HIGH ACRES FARM  
GREAT BOURTON  
BANBURY  
OXON OX17 1RL  
[REDACTED]

22<sup>nd</sup> August 2020

Re: Application 20/02060/F  
CHANGE TO USE OF LAND TO MIXED USE FOR THE KEEPING OF  
HORSES (EXISTING) AND AS A RESIDENTIAL CARAVAN SITE FOR  
4 GYPSY FAMILIES, EACH WITH TWO CARAVANS (INCLUDING NO  
MORE THAN FOUR STATIC CARAVANS/MOBILE HOMES),  
TOGETHER WITH THE LAYING OF HARDCORE.

# SITE LAYOUT PLAN

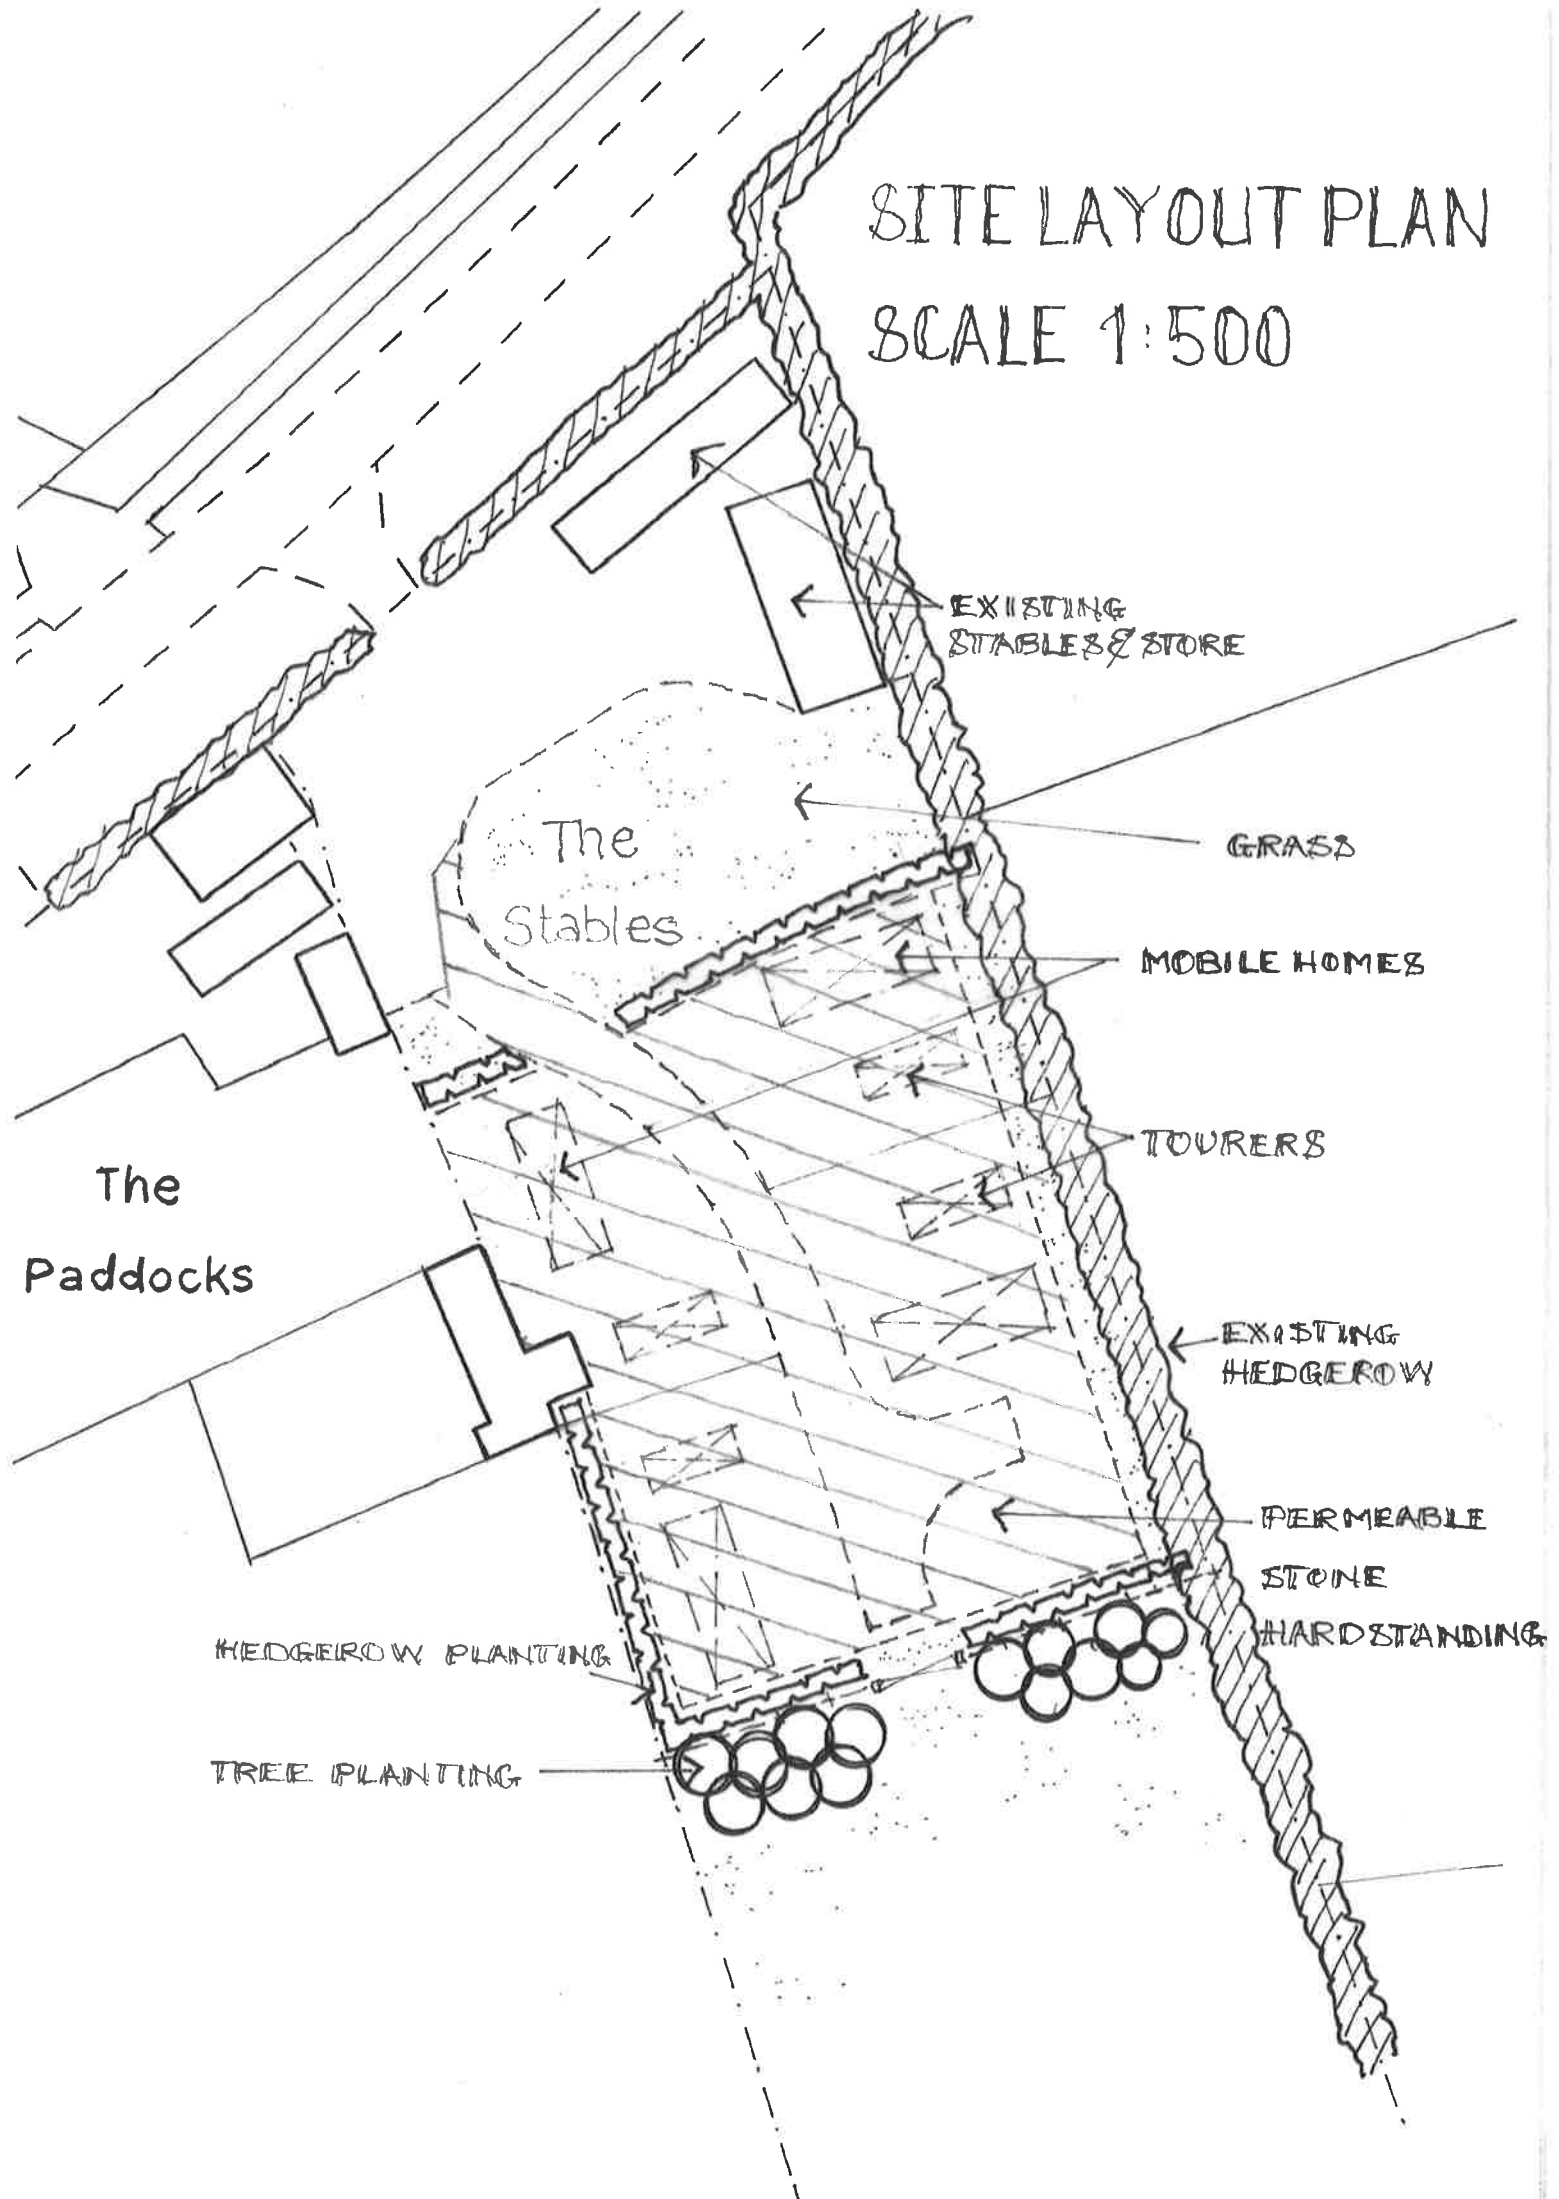
The application does not give any specifications as to the proposed Sewage Disposal Plant. Any overflow or leak from a sewage system would have only one course to take which is into a ditch that joins Sow Burge brook that runs through the grounds of Cropredy Primary School and eventually into the Oxford Canal.

The site is subject to flooding (photographic evidence available) and water lies on the site throughout the winter. The site has already previously had 100's of tonnes of builder's waste tipped on it for hard standings and the construction of the large building on the adjacent site (now in the same ownership) has damaged a drainage system put in in the 1960's and has also destroyed the natural drainage channels of the former ridge and furrows. This has compromised the land drainage on nearby land and causes bad flooding as the water cannot now drain away. Any further hardcore for hard standings will only exacerbate the situation and should not be allowed.

The Agents letter and site plans fail to give indication to the fact that the site has a Public Right of Way running diagonally across it! There are already problems where a dog is running loose on the site that has challenged several members of the public when using the path. This has been reported to the Local Authorities. The occupants of the type of caravans/static homes in this proposal very often have dogs running loose and this would no doubt intimidate people and compromise their safety. It would not be in the interest of public safety to allow the potential of this to arise.

The application states that the site cannot be seen from a road or public area but it is visible from the road and footpath from Great Bourton to Cropredy and the Right of Way from Little Bourton to Cropredy that crosses the site. The site is also very exposed and prominent when looking down from the village of Great Bourton. Bearing in mind a planting scheme to protect this was put as a condition on the adjacent site, the building was completed but five years on the planting has still not been done and has never been enforced by CDC. This does not give the public any confidence that breaches of conditions on any applications that occur would be addressed by the Planning Authority.
